CITY OF ALBUQUERQUE

PLANNING DEPARTMENT – Development Review Services

RE: Izzat Subdivision (File: C20D069)
Grading and Drainage Plan, Engineer's Date 2-11-2014
Certification Date: 12-20-15

1 GRADING PLAN
1"=20'

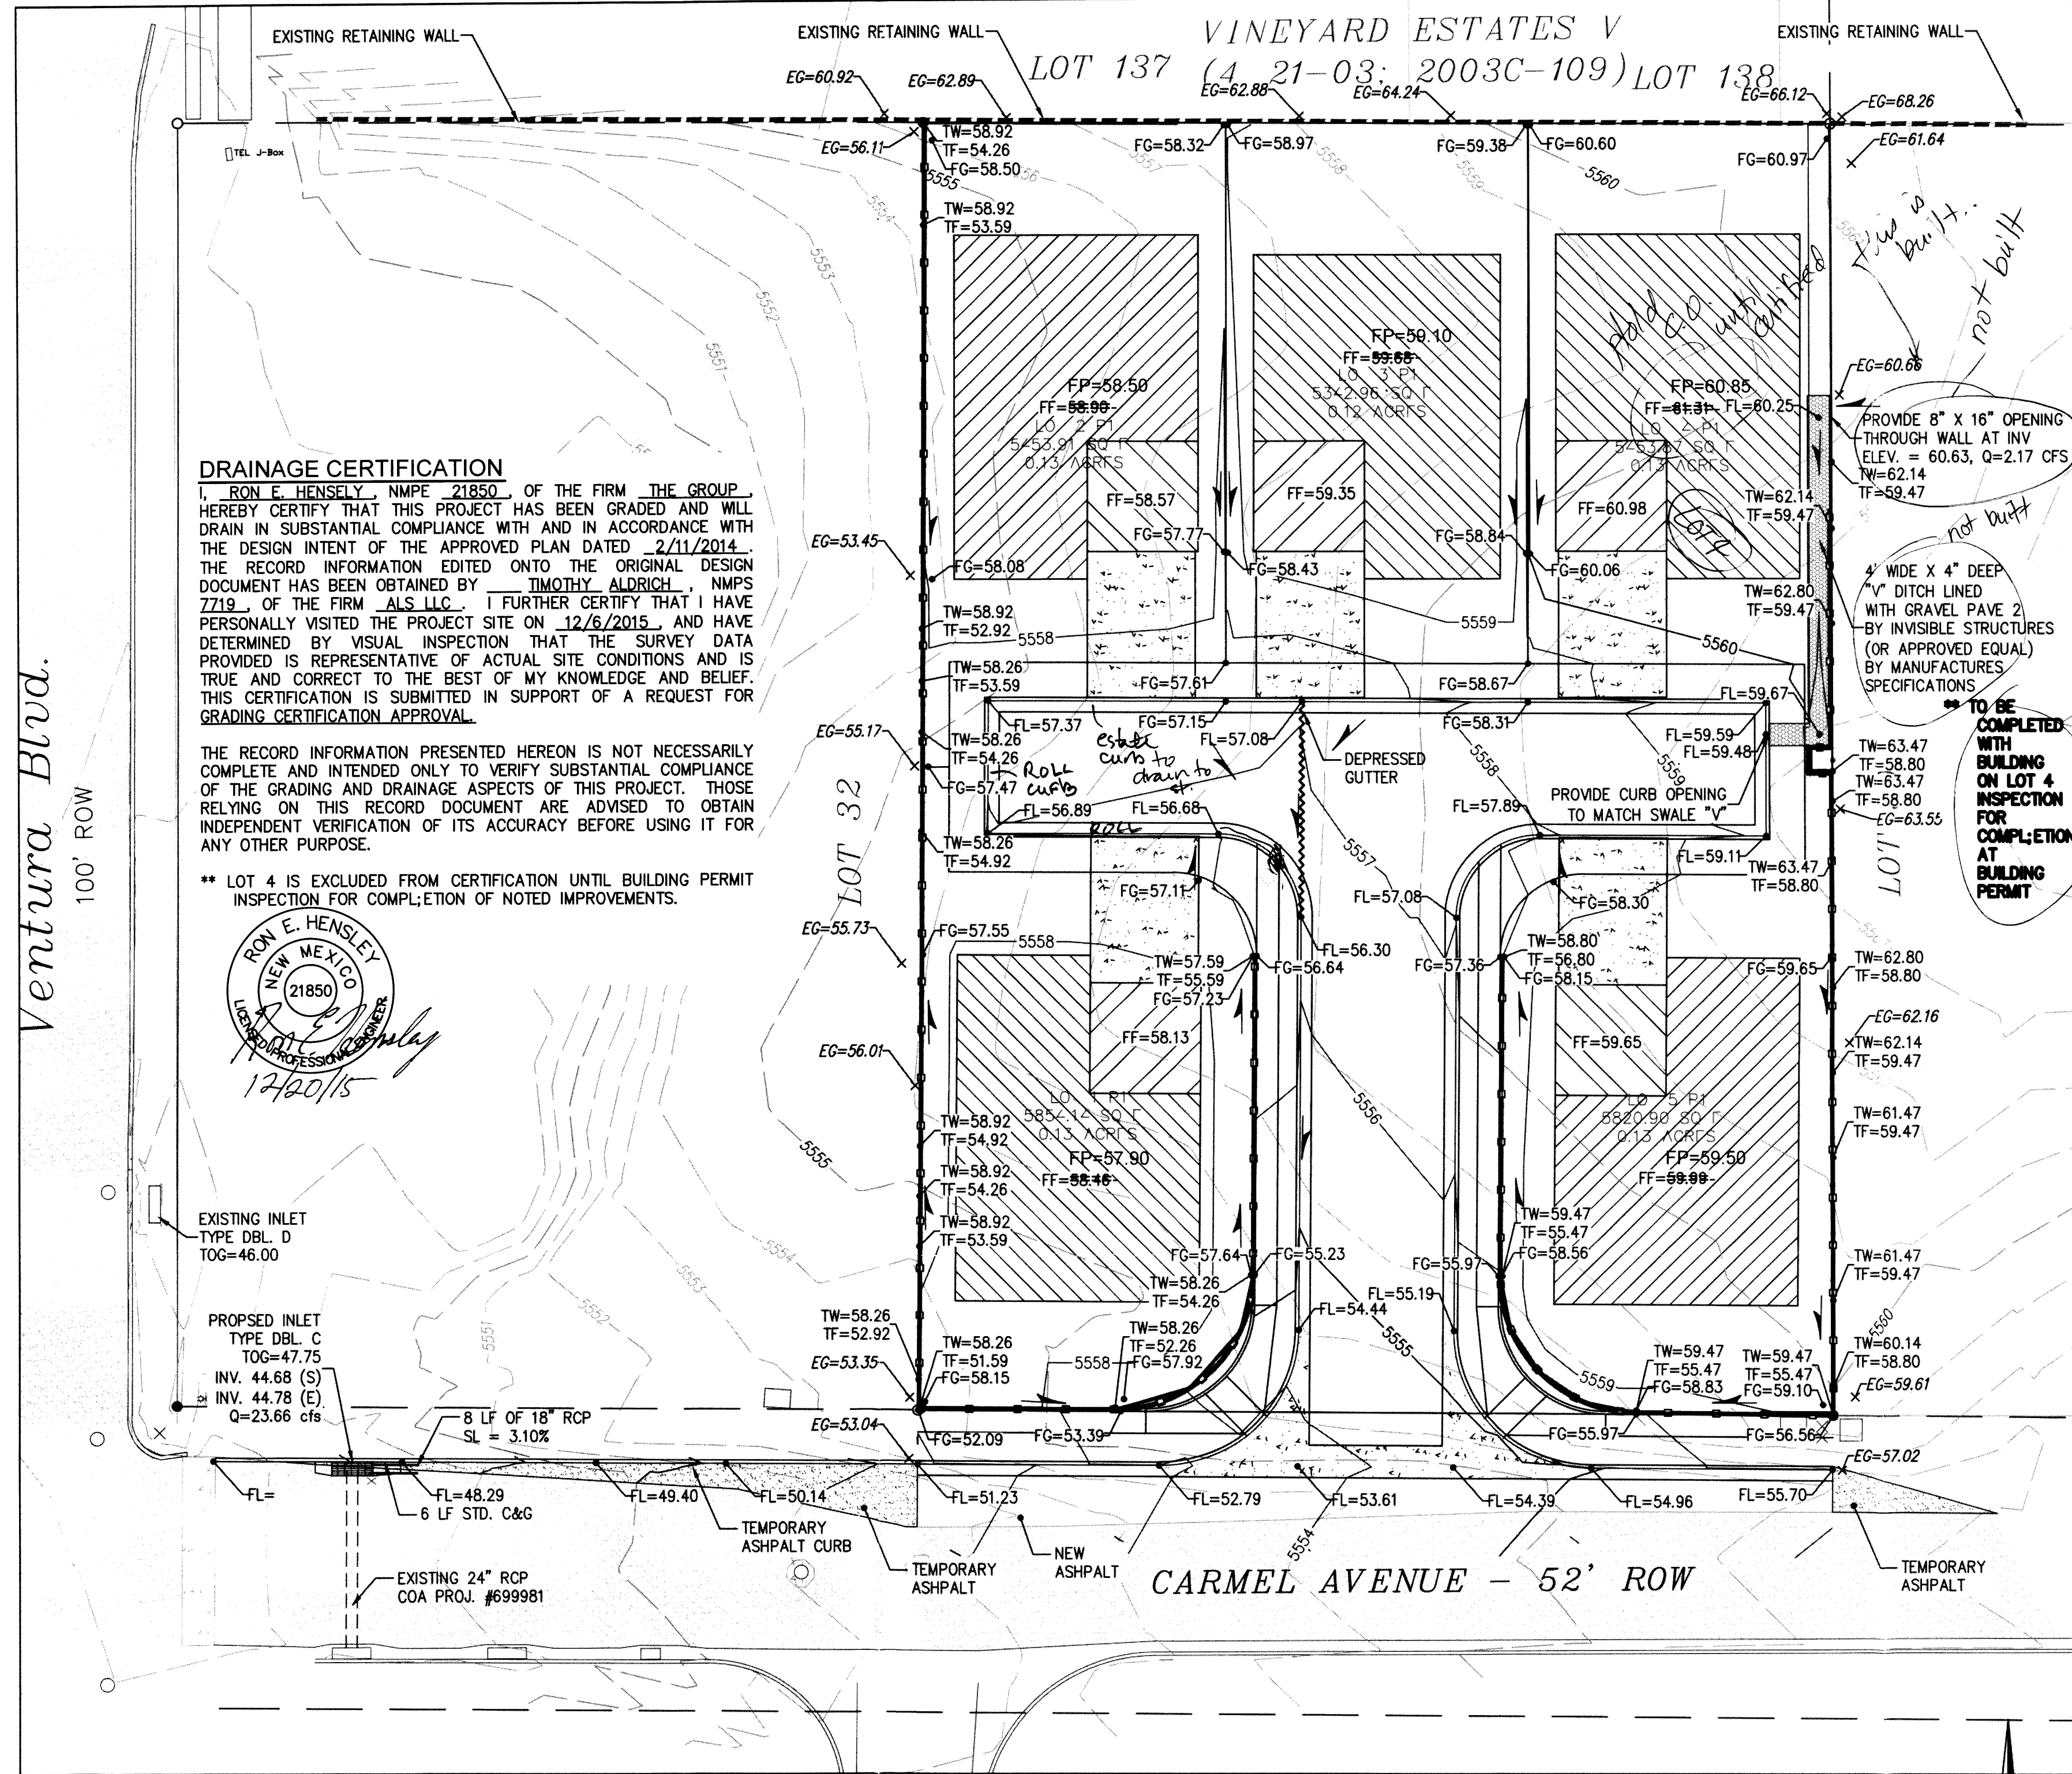
Based upon your Engineer's Certification submitted on 12-22-2015, the above referenced plan is adequate and satisfies the Grading and Drainage Certification for Release of Financial Guaranty, with the exception of the wall openings and swale along the NE property line. C.O. for Lot 4 will be contingent on a future submittal certifying that the swale and wall openings along the NE property line are built.
